Application No: M/92/20/HH
Site Address: 67-69 Lych Gate House Elmer Road Middleton-On-Sea PO22 6EH
Description of works: Two storey rear extension and single storey front extension, first floor front extension

Thank you for your internet representation made on 24th January 2021 which has been recorded as an objection with the comments as follows:

Proposed Ground Floor Plan

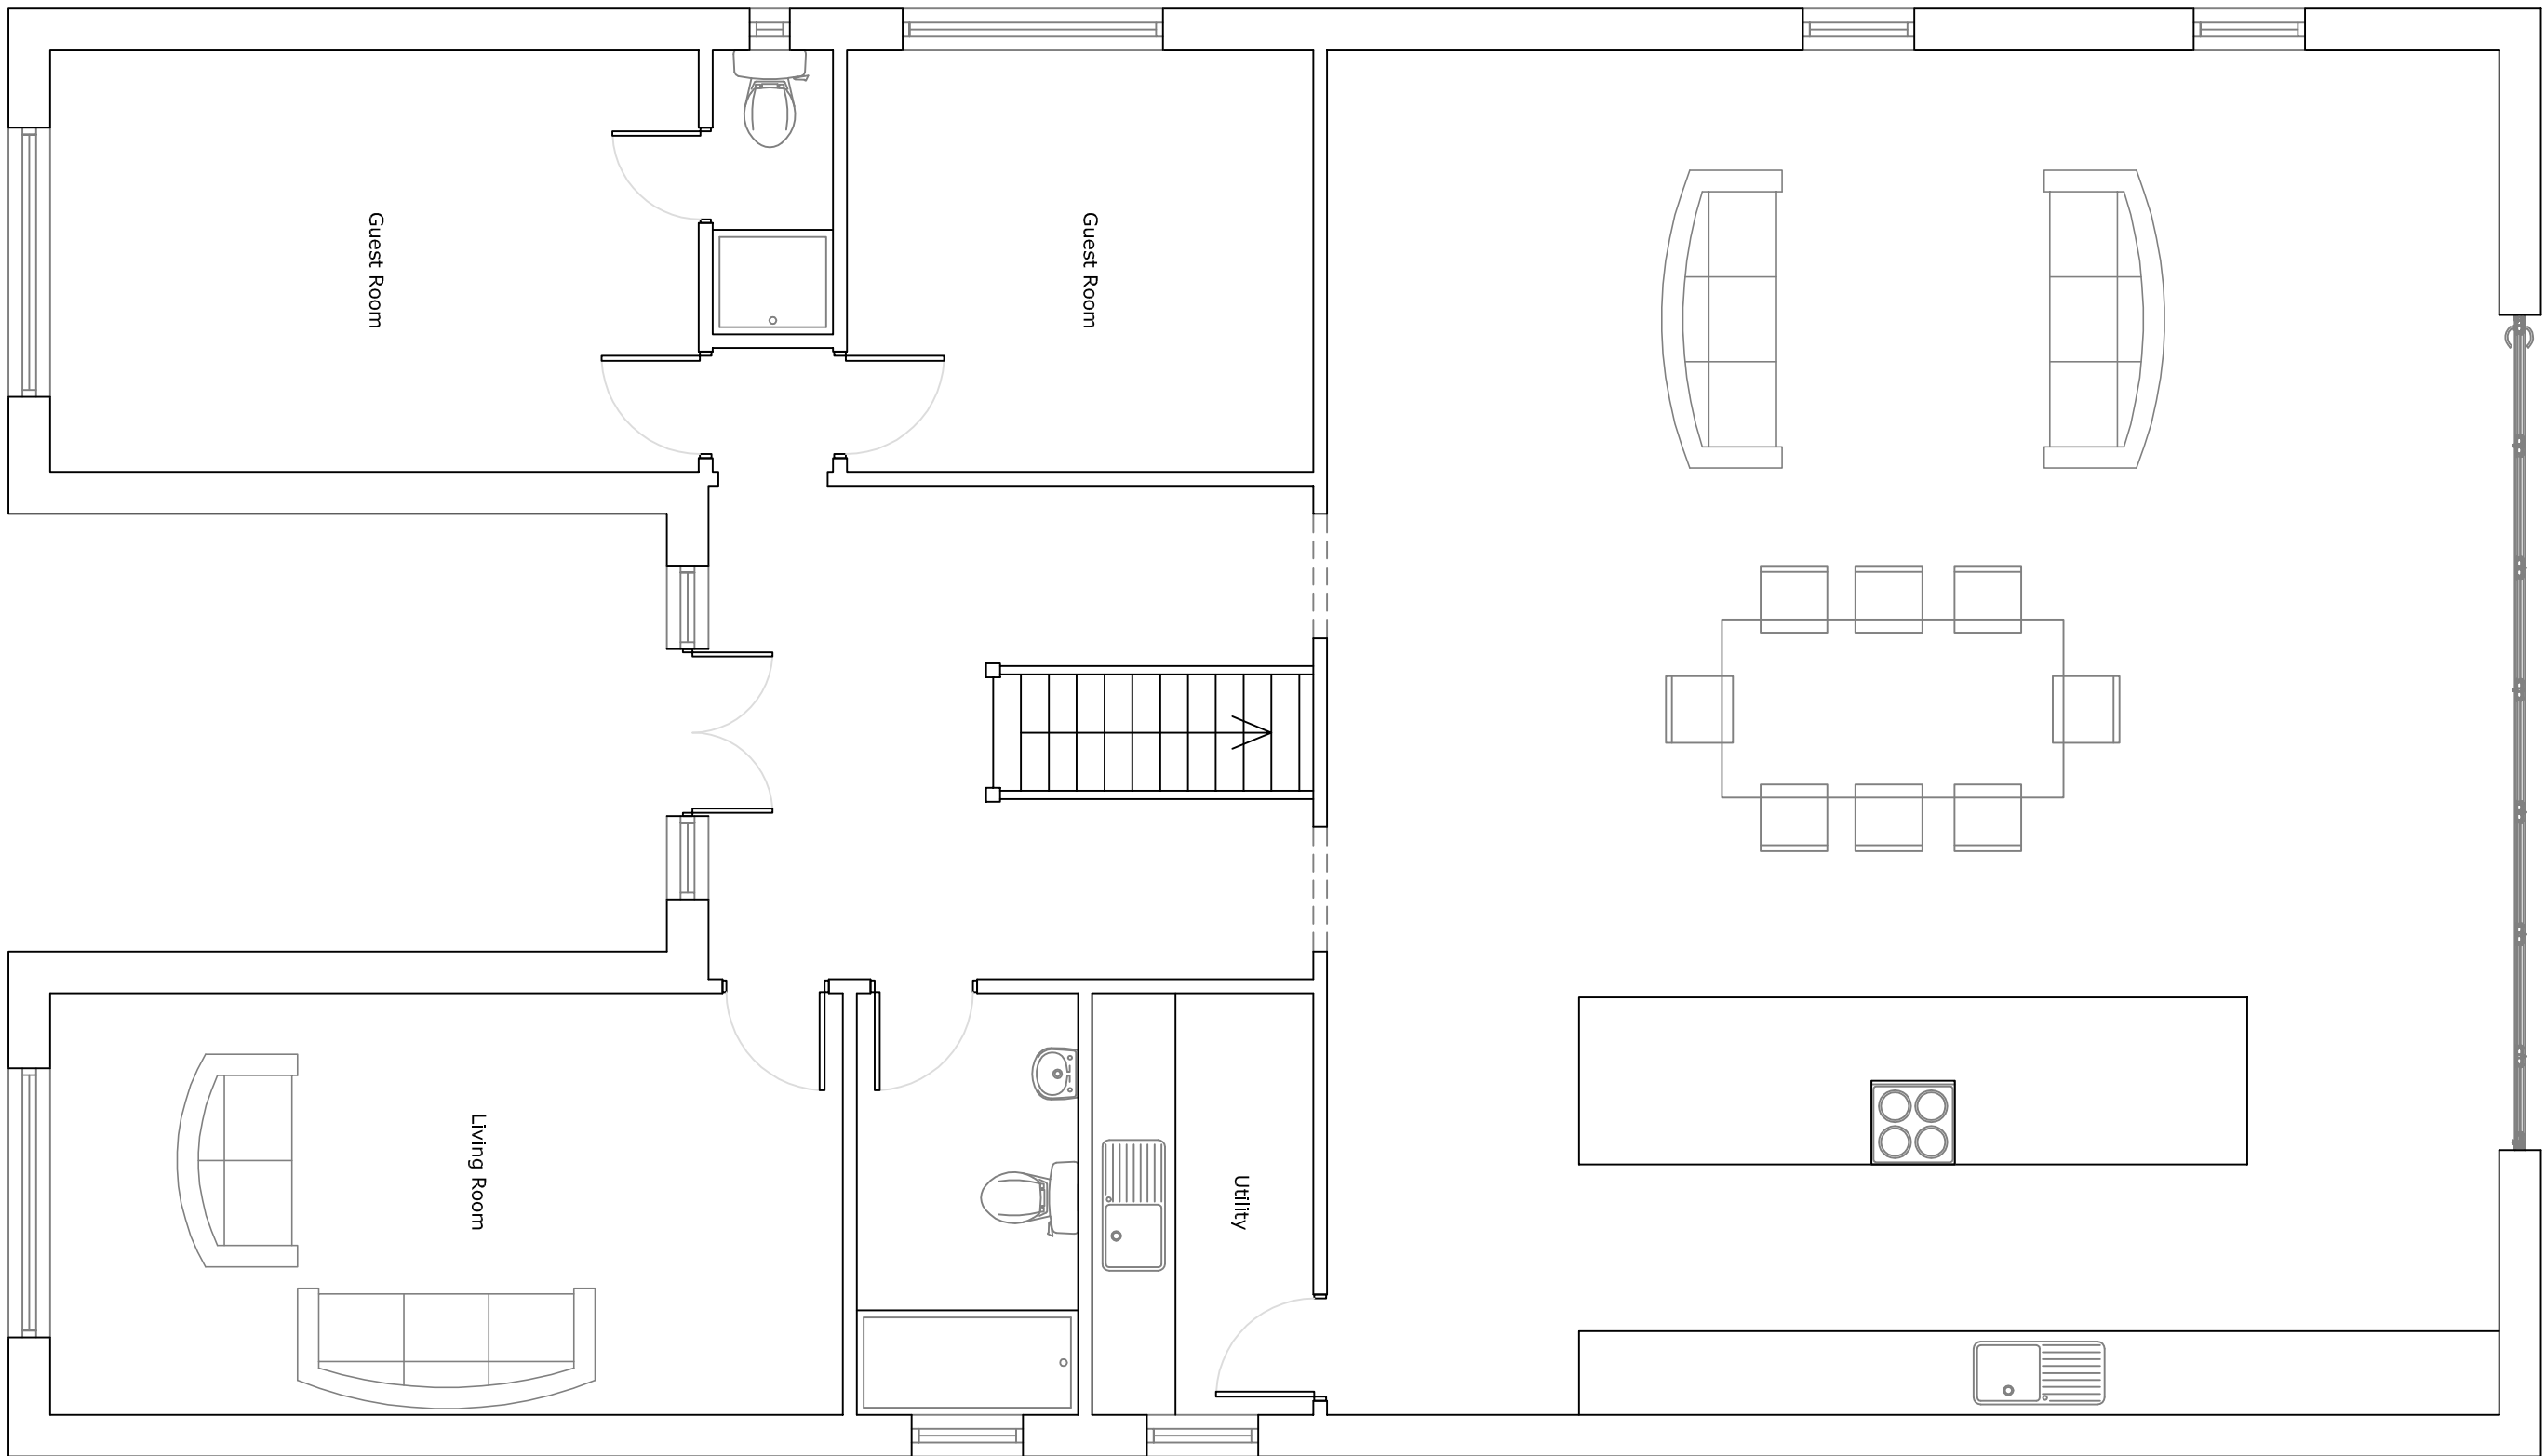
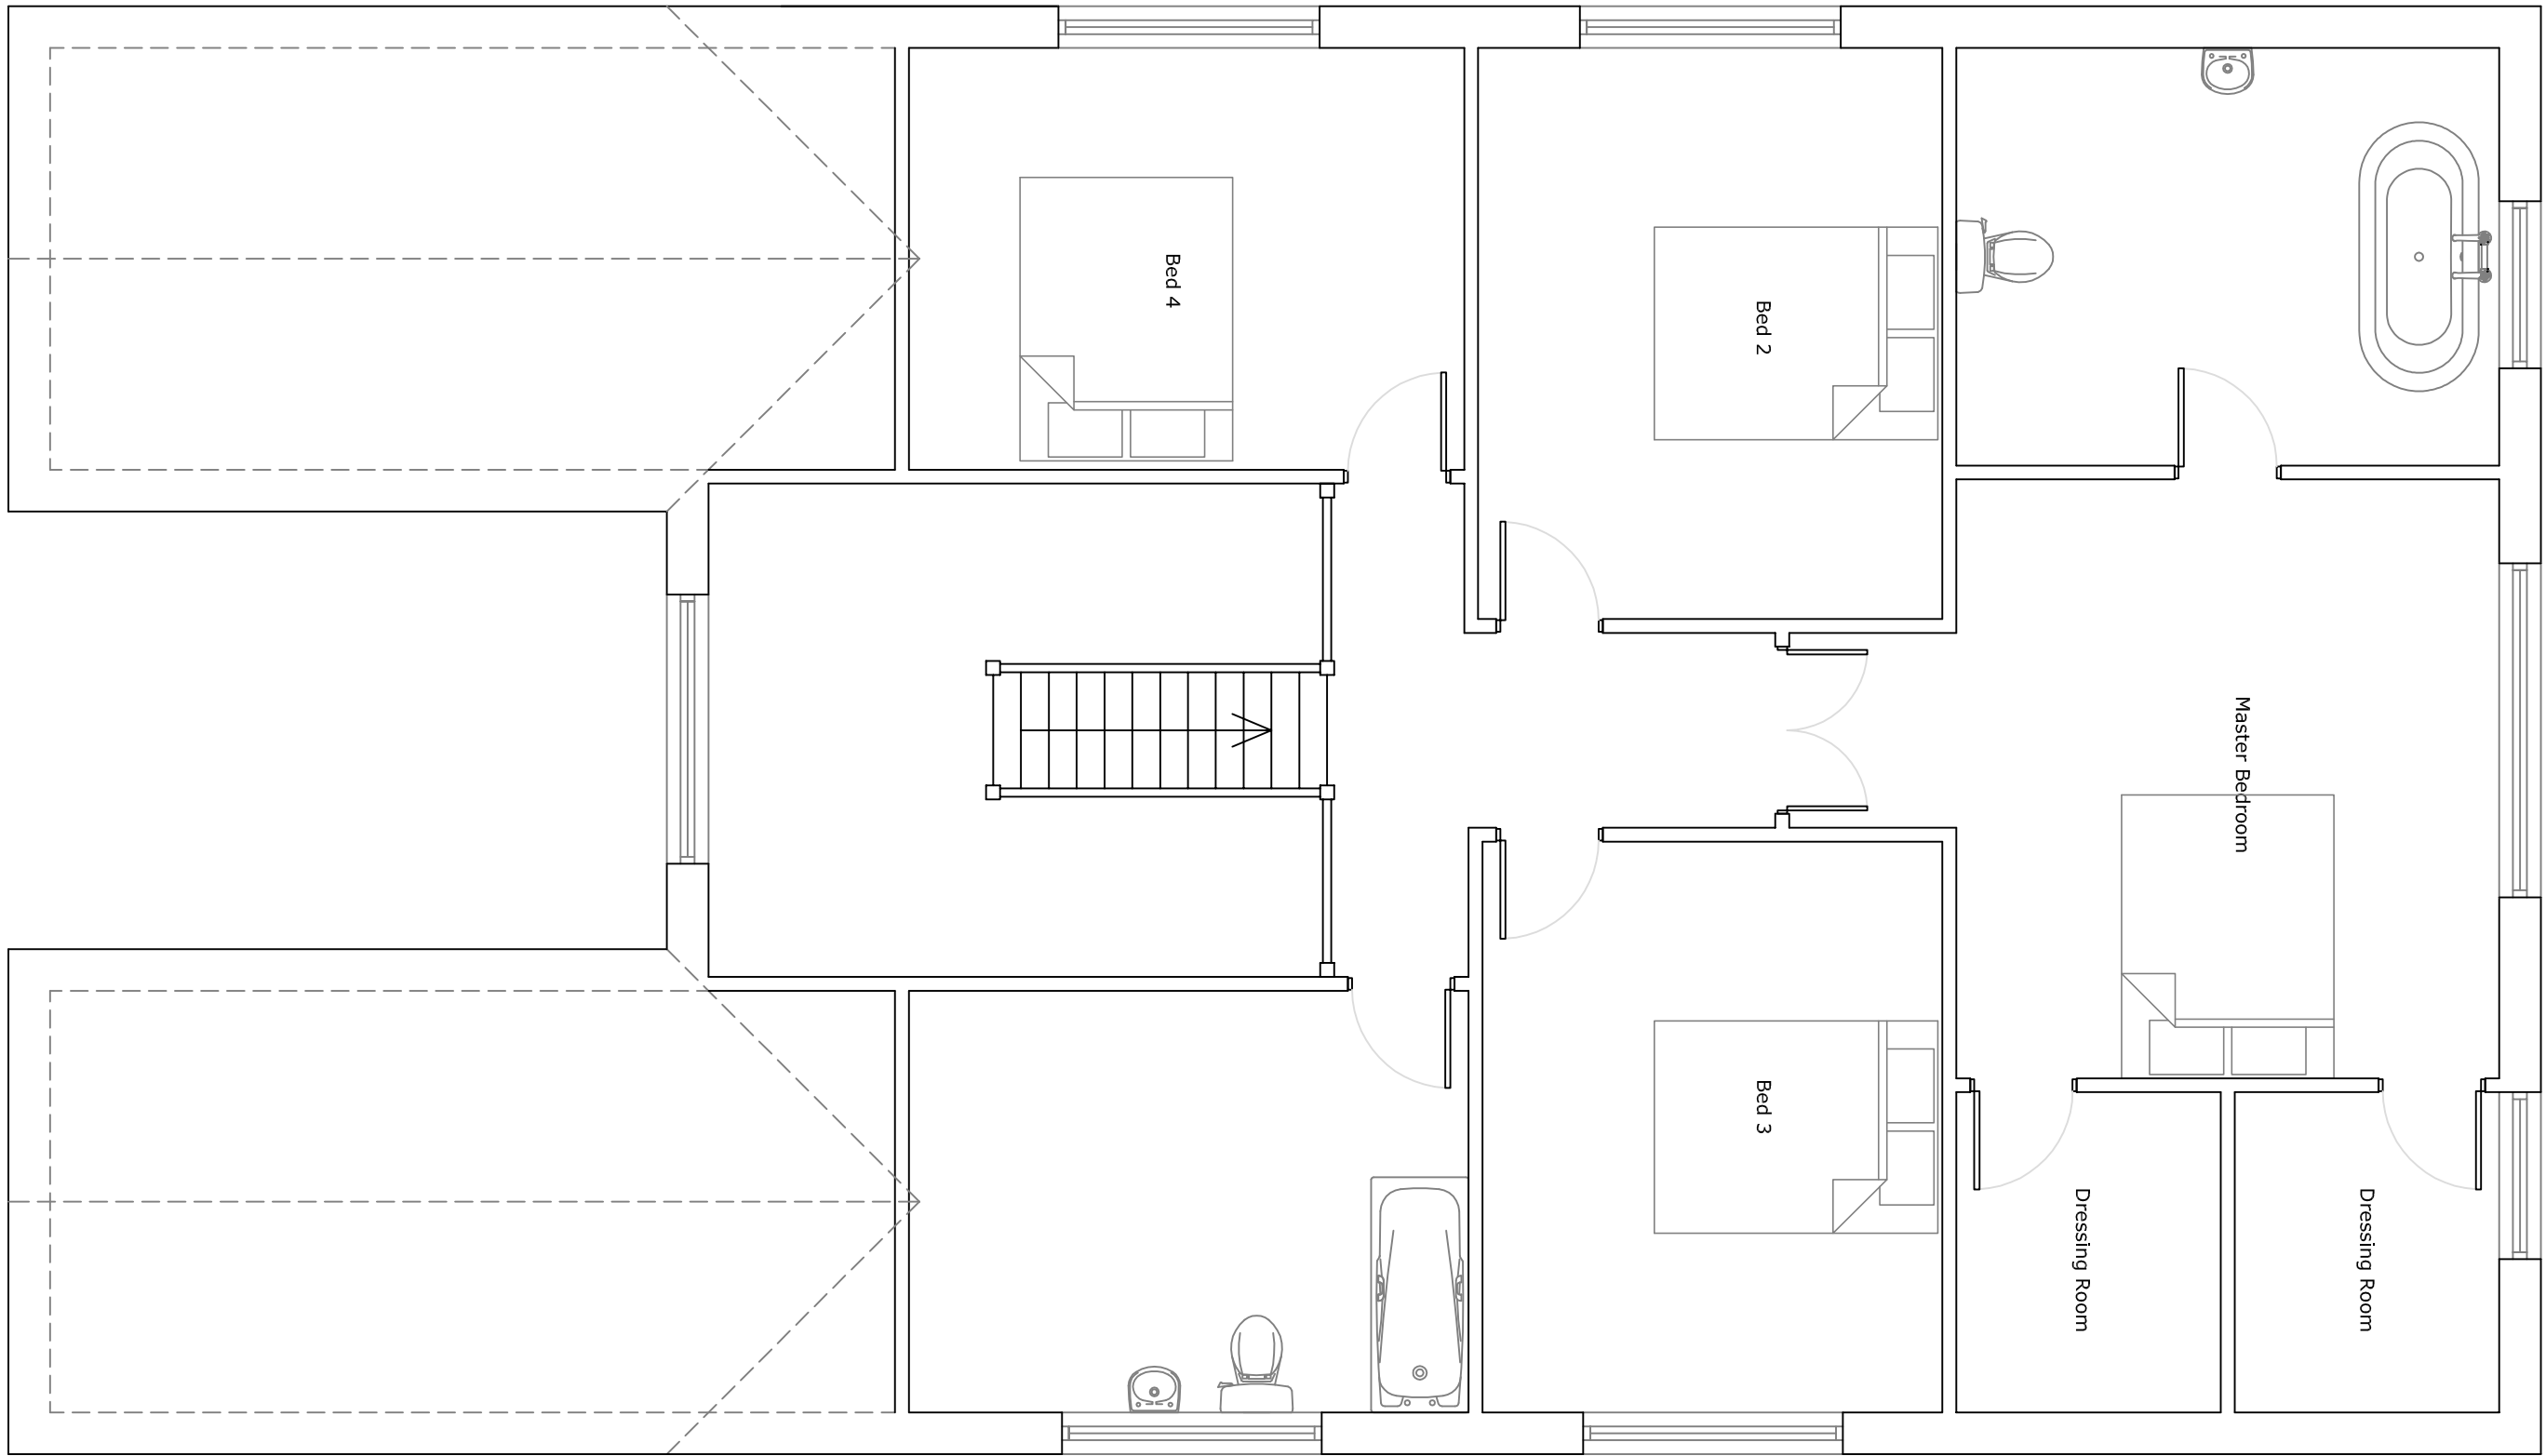
The sketch plans are inaccurate in that they don't show our property next door in enough detail to understand the full impact of the proposed extension. The east-facing windows of the development will look directly into our main bedroom and straight into our large kitchen patio windows. This is a gross invasion of privacy, and will make me feel uncomfortable in my main living areas. This would not have been a problem if the owners of 67-69 Elmer Road had not felled our boundary trees (growing in our garden) which gave us total privacy.

I am also concerned about the impact on flooding. Since they paved their front drive our garden has suffered significant flooding. There is a great concern that the proposed extension will further increase this risk and threaten the garage and kitchen with flooding in future, not just the garden which is often under water now.
